# CITY OF ALBUQUERQUE

**Re: Plumbers & Pipefitters Training Facility  
421 Arizona SE  
Request for Permanent C.O. - Accepted  
Engineer's Stamp dated: 7-2-15 (L18D074)  
Certification dated: 2-12-16**

**Re: New Training & Storage Facility  
421 Arizona St SE  
Grading and Drainage Plan  
Engineer's Stamp dated: 7-2-15 (L18D074)**

**Re: New Training & Storage Facility  
421 Arizona St SE  
Grading and Drainage Plan  
Engineer's Stamp dated: 6-12-15 (L18D074)**

A1 GRADING AND DRAINAGE PLAN  
SCALE: 1"=10'

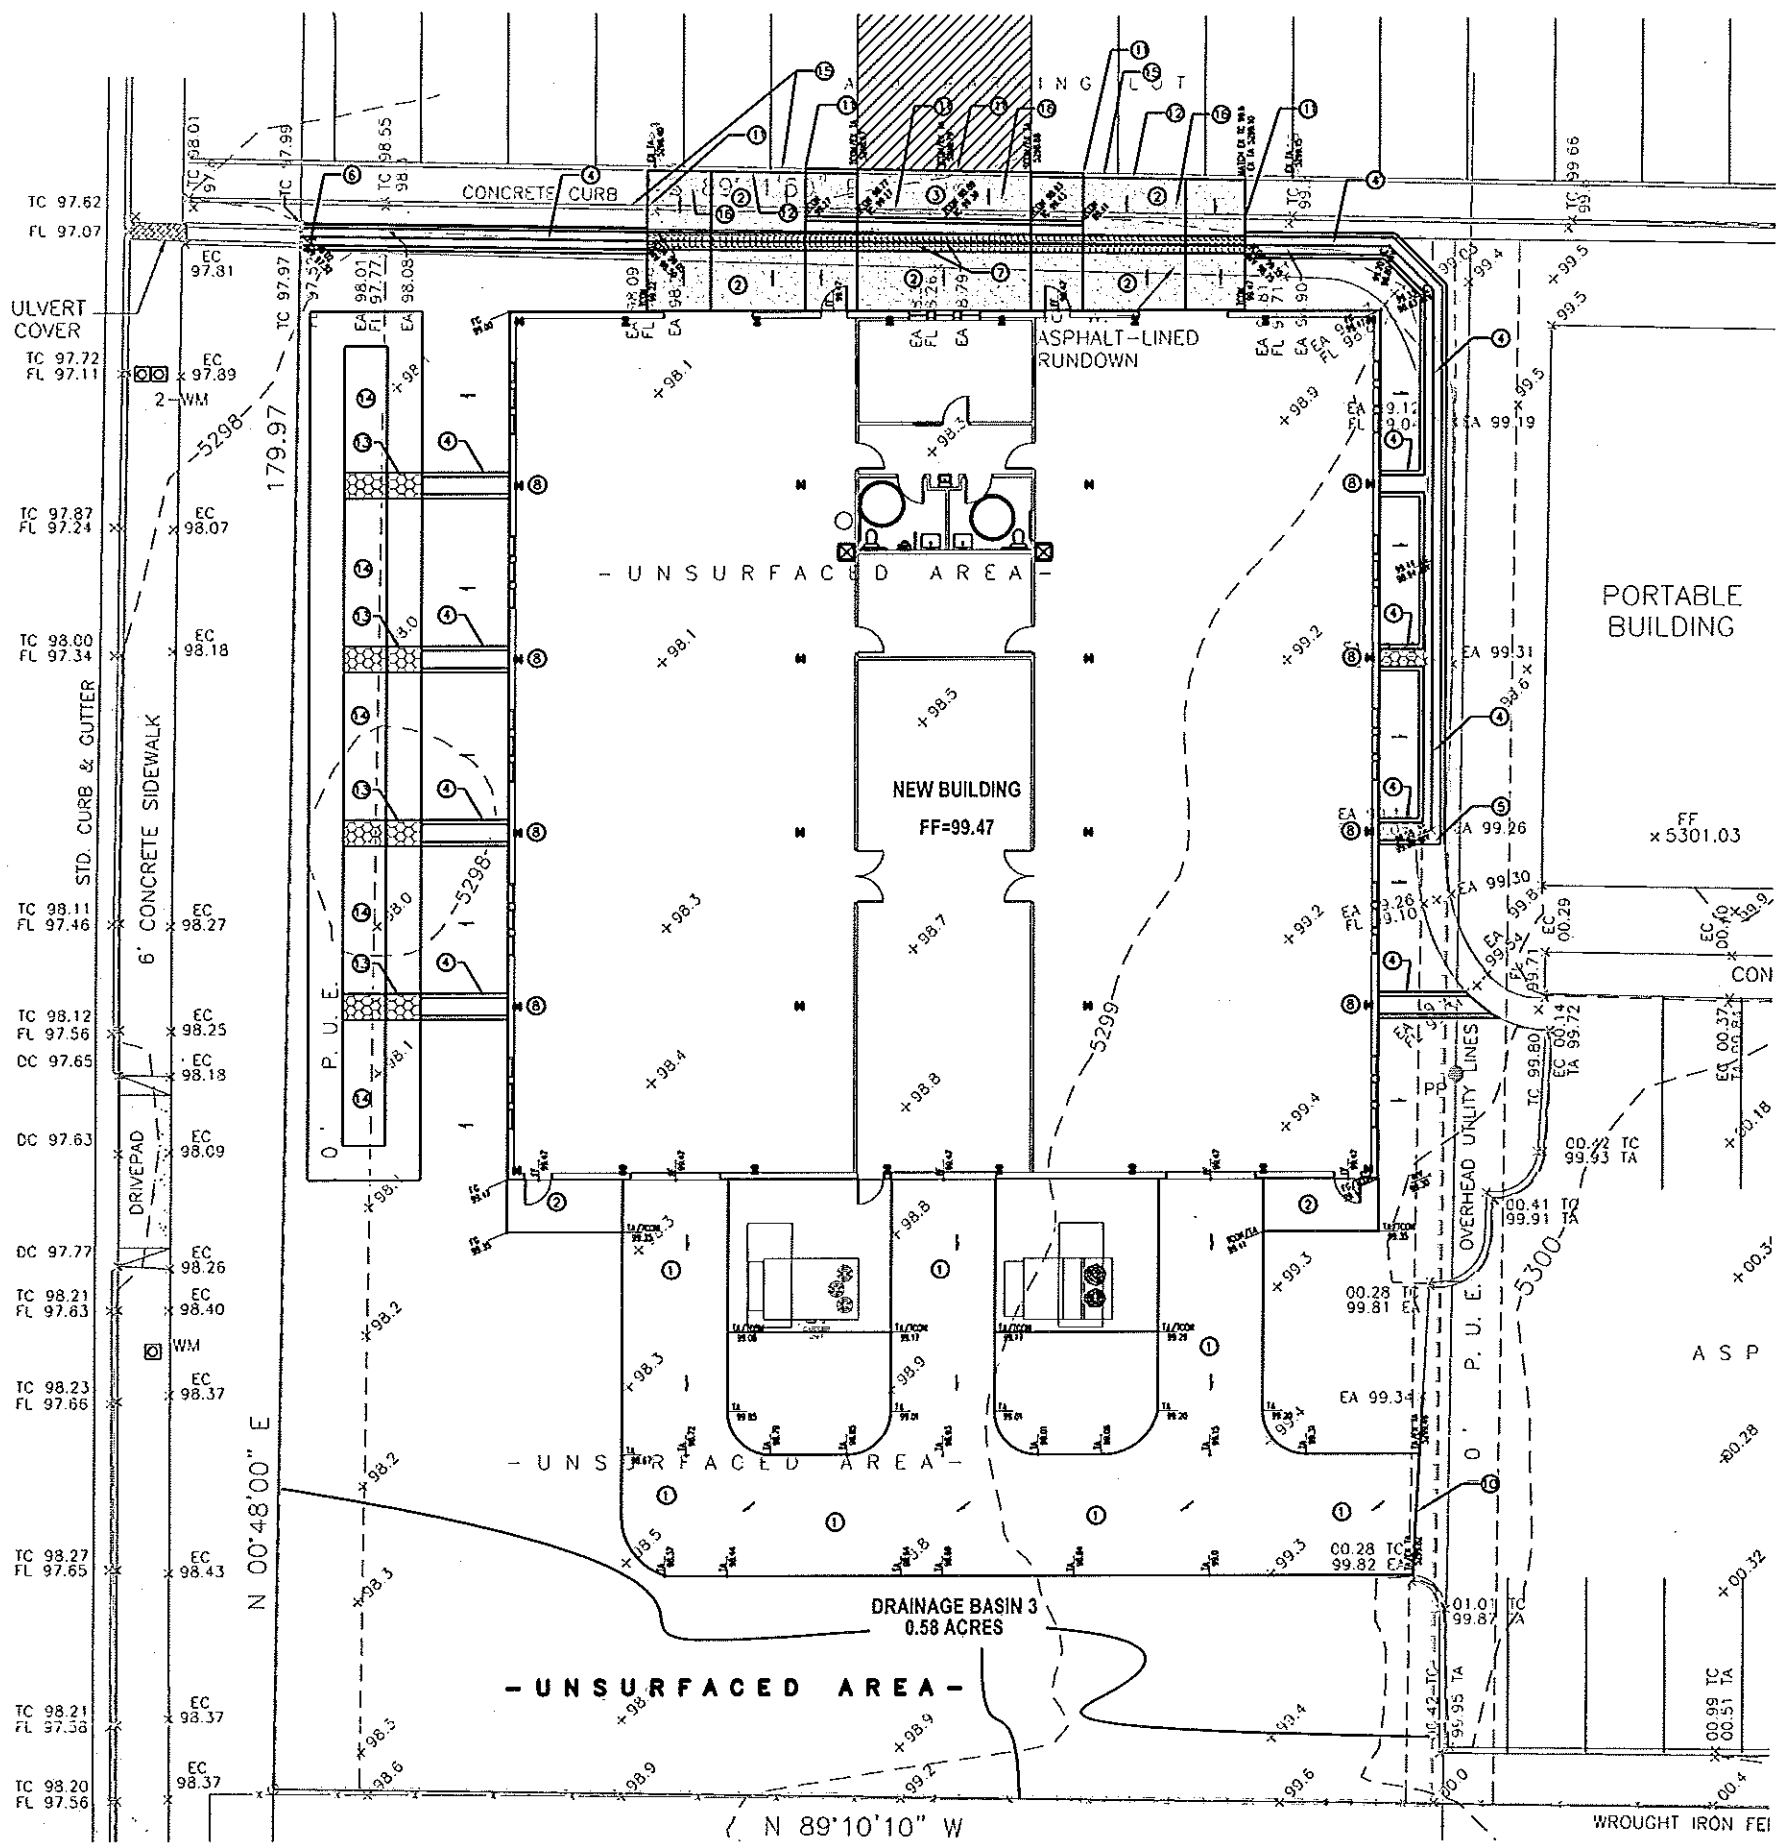
- Provide how flows are leaving the FF pond. What is the pond bottom?
- Provide the type of surface in the south area. A look at the aerial map shows pavement. How will the flows exit this area?
- Provide a FF pond for the downspouts on the east side of the building.
- Provide a letter of approval from the owner to the north of this site for grading and paving in their property. Also provide a FF pond for this area. What does the hatched area represent?
- Sheet C-501 shows a typical pond section with a berm. Where is this berm located? If on the east side of the pond, how will the concrete channels enter the pond?
- Provide a basin map of the entire area.

1. Provide how flows are leaving the FF pond. What is the pond bottom?  
*The northwest corner of the first flush pond will act like a natural spillway. The pond bottom invert elevation is 97.0.*

2. Provide the type of surface in the south area. A look at the aerial map shows pavement. How will the flows exit this area?  
*The area in question is actually dirt/base course as it stands today. The flows will exist through a swale which we have added on sheet C-102. The new swale will begin near the east edge to the south of the property and run west then head northeast around the paved drive area and northwest to the first flush pond on the west side.*

3. Provide a FF pond for the downspouts on the east side of the building.  
*A new first flush pond has been provided on the corner of the southeast side of the building. Provided the site constraints, we have made every feasible effort to accommodate a FF pond to accommodate the east side of the building.*

4. Provide a letter of approval from the owner to the north of this site for grading and paving in their property. Also provide a FF pond for this area. What does the hatched area represent?  
*The property to the north is owned by the same owner as this property. A letter from the property owner has been attached. Provided the site constraints, a FF pond in this area is not feasible. We have made every effort to capture as much runoff from paved areas as possibly feasible. The hatched area represents parking lot striping within the north parking lot area.*

**D5** TYPICAL POND SECTION DETAIL  
SCALE: NOT TO SCALE

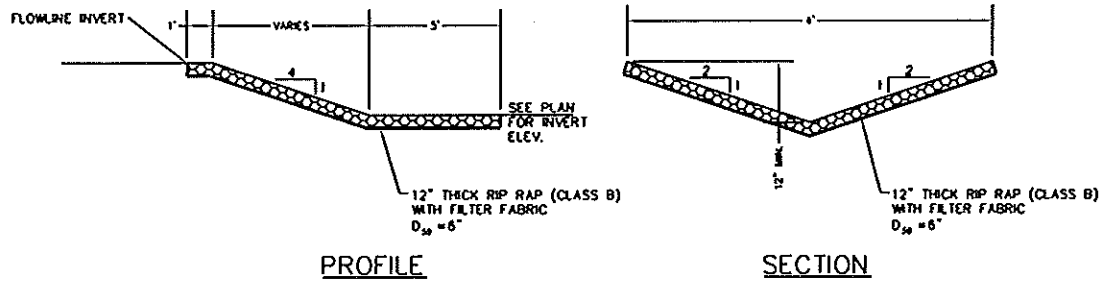
5. Sheet C-501 shows a typical pond section with a berm. Where is this berm located? If on the east side of the pond, how will the concrete channels enter the pond?

*The berm has been removed from the detail on sheet C-501. The flows will be able to enter the pond through the concrete channels.*
